**Consultation Response from Mike Hibbert,
KC Waste Strategy(Refuse & Recycling)**

2024/92699 rear of, 51, Turnshaw Road, Kirkburton, Huddersfield, HD8 0TH

Erection of one dwelling and associated works

Responding Ref: WPS 24-064

SITE PLAN
1:200@A3

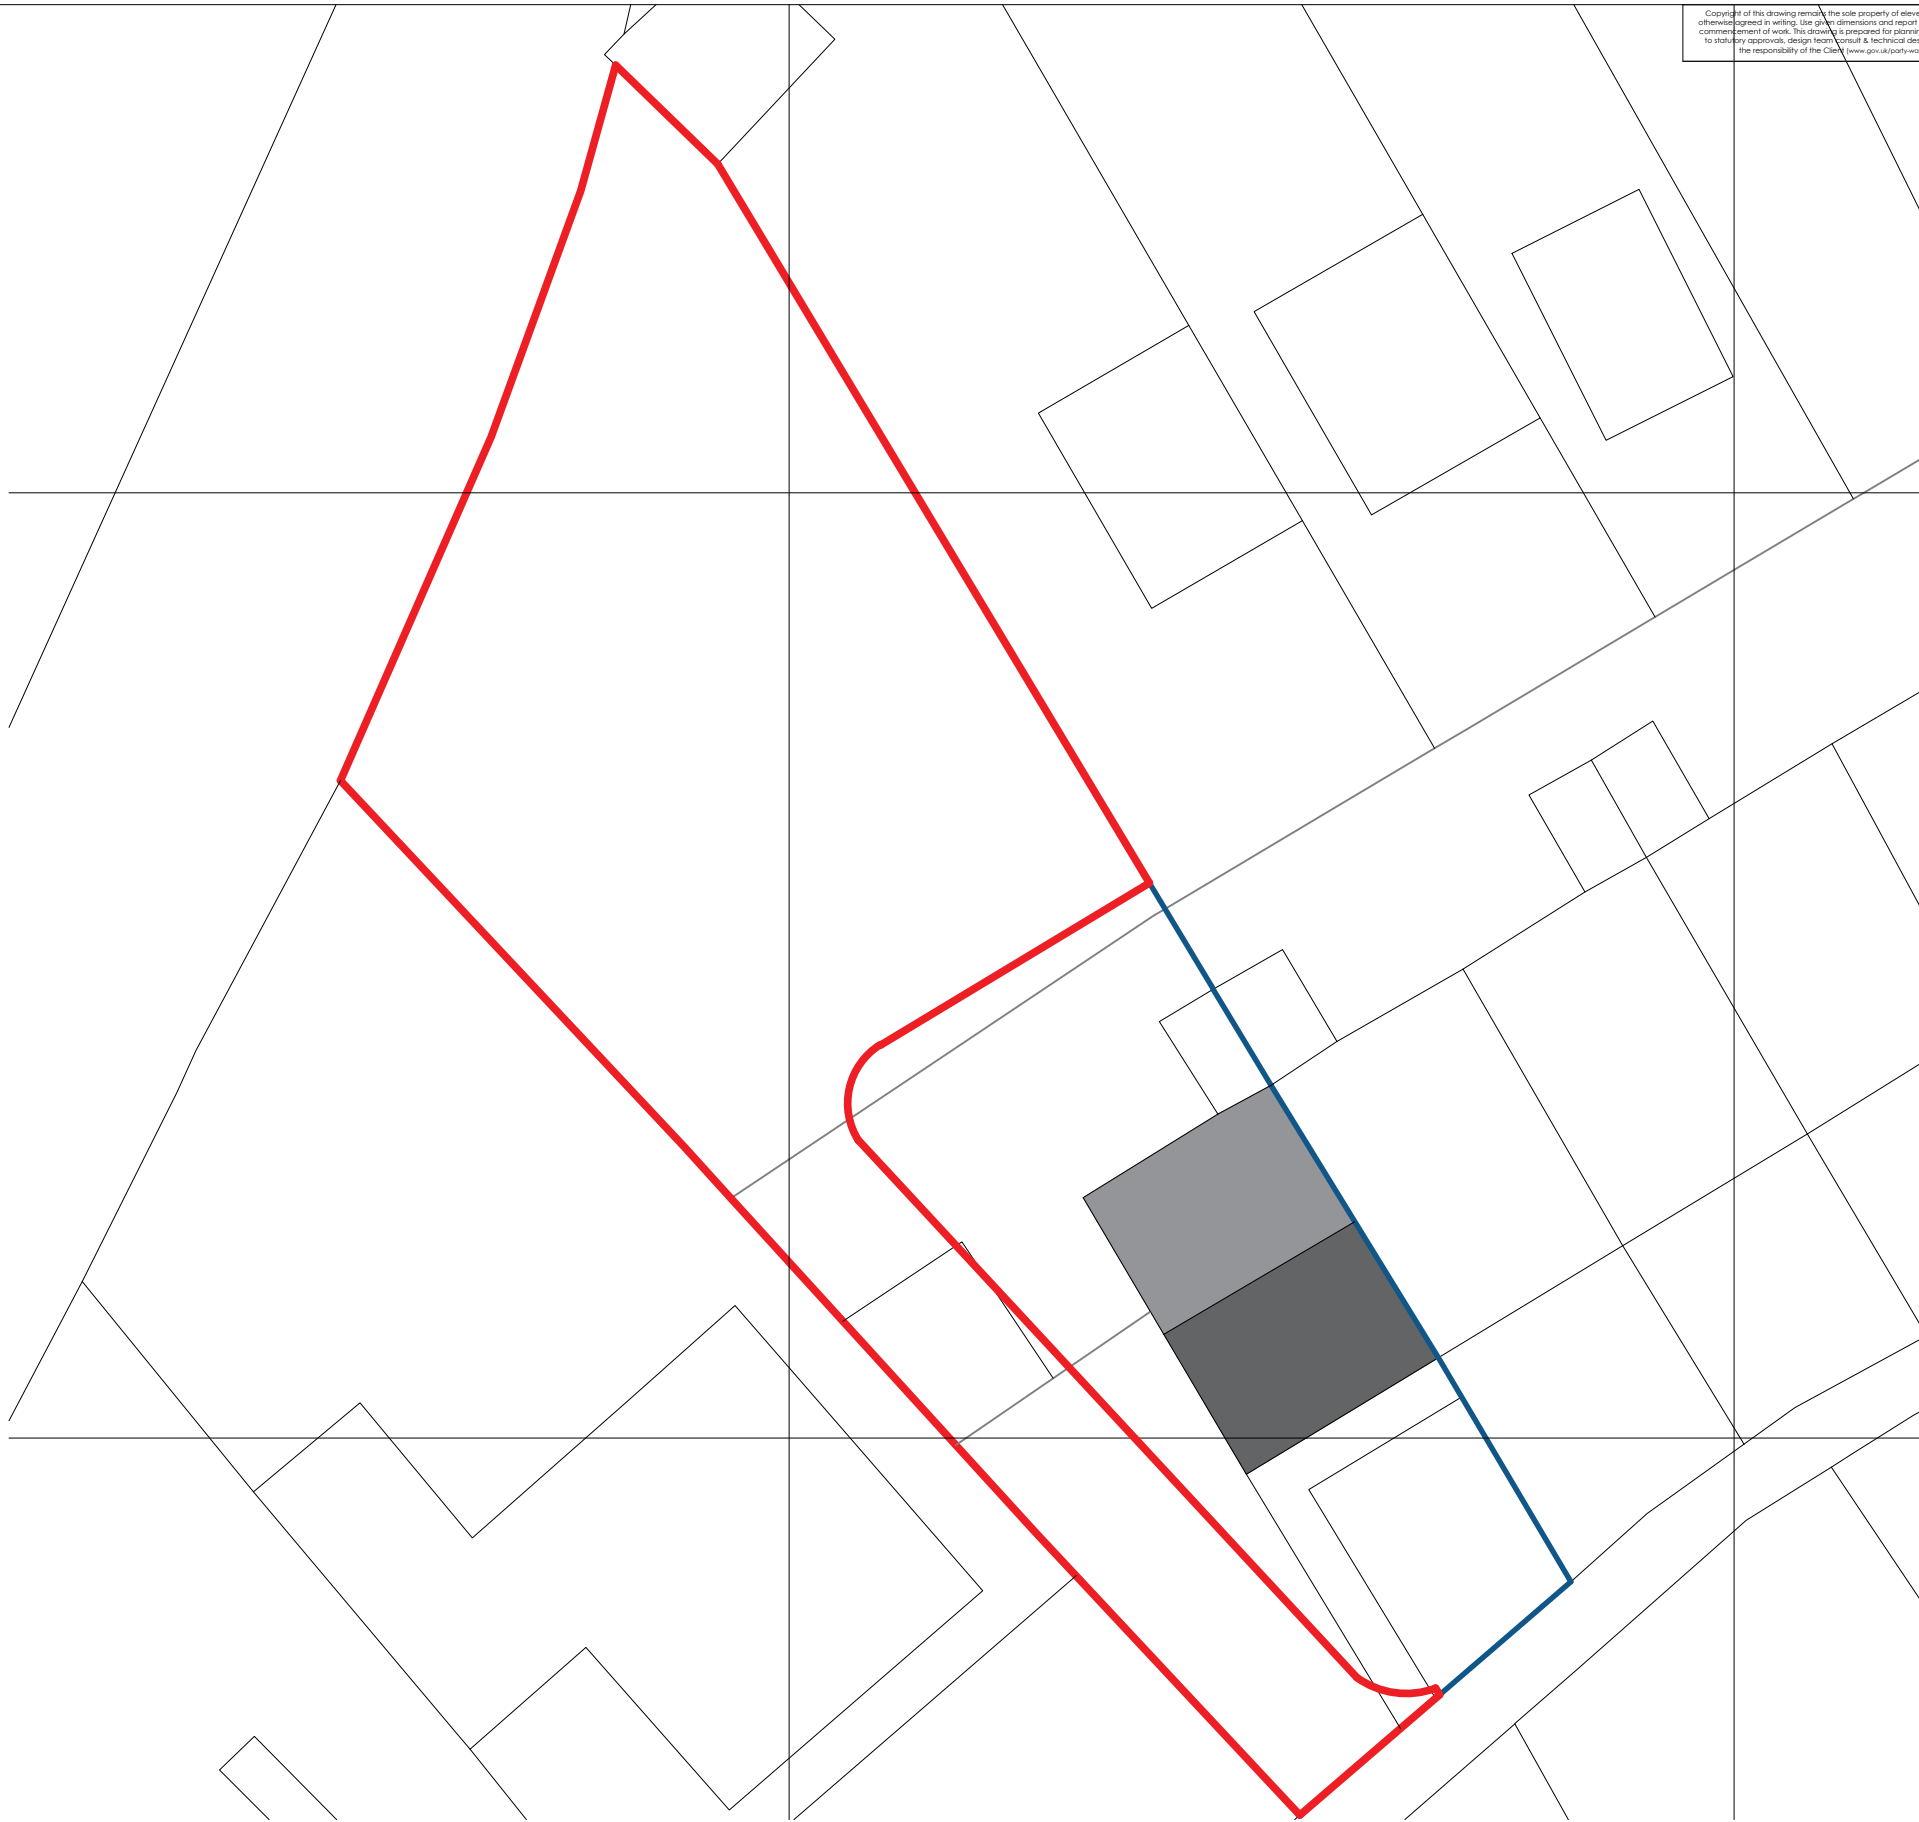
A Proposed site plan Ref 0467_TURN_102 dated 16.08.24 is not annotated with any details relating to waste storage or bin presentation.

- Space will be required for 3 x 240ltr bins at the property, 1x240ltr Residual, 1x240ltr Recycling and as the property has a garden the space, to accommodate a third bin for garden waste or to accommodate future changes to waste collection due to the implementation of Simpler Recycling legislation. As the proposed dwelling has a private garden, opportunities to encourage composting should be sought to better meet the council's 'clean and green' objectives for waste reduction.

- Guidance indicates the storage footprint for a 240ltrs wheeliebin is 940mm x 780mm with enough room to allow removal of the bin from the storage location. The floor plan for storage must be large enough to accommodate 3 x240ltrs bins for each dwelling.

- Preference is for storage of waste bins within the curtilage to avoid impact on the Streetscene and this should be achievable on this site.
- The WCA will not take a Refuse Collection Vehicle into a private drive. The layout plan must show the location of a Bin Collection Point (BCP) for presentation of wheeliebins adjacent to the adopted highway but not on the pavement. It is important to ensure that bins do not cause obstruction to pedestrians or other highways users when presented

for collection. Bin presentation space should be identified within the plot, on a hard surface and where a refuse collection vehicle (RCV) can be easily reached.

- The proposed develop must not result in impaired access to or negatively impact upon bin storage and bin collection from Number 51.
